Application for a non-material amendment following a grant of planning permission.

SINGLE STOREY REAR EXTENSION AND TWO STOREY FRONT EXTENSION

Reference number: EP/148/18/HH

ADDITION OF A ROUND, 600mm DIAMETER, WHITE PVCU WINDOW TO FIRST FLOOR EN SUITE BATHROOM ON EAST ELEVATION

PROPOSED EAST ELEVATION 1:100

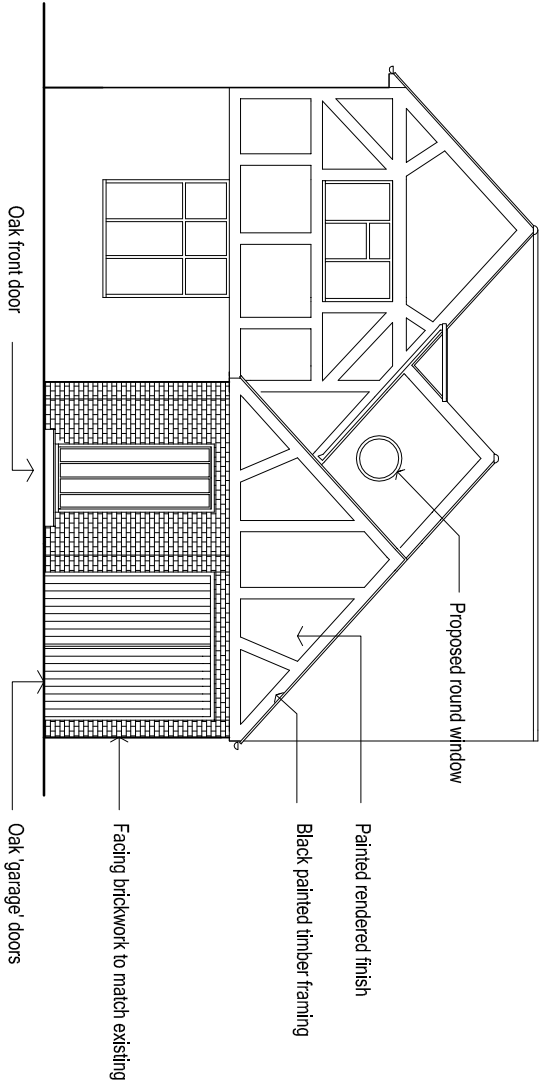
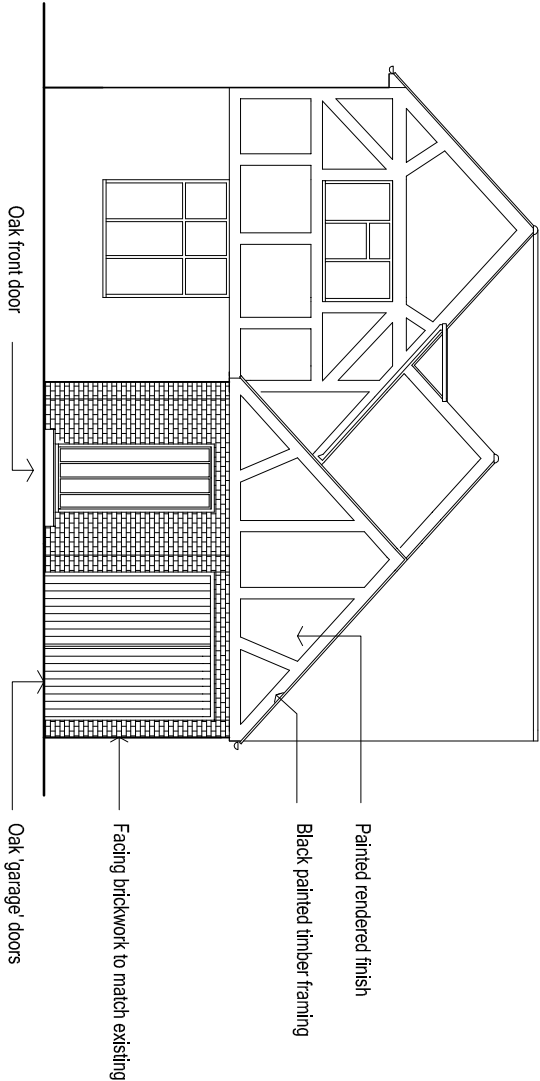
TO ALLOW MORE LIGHT INTO BATHROOM
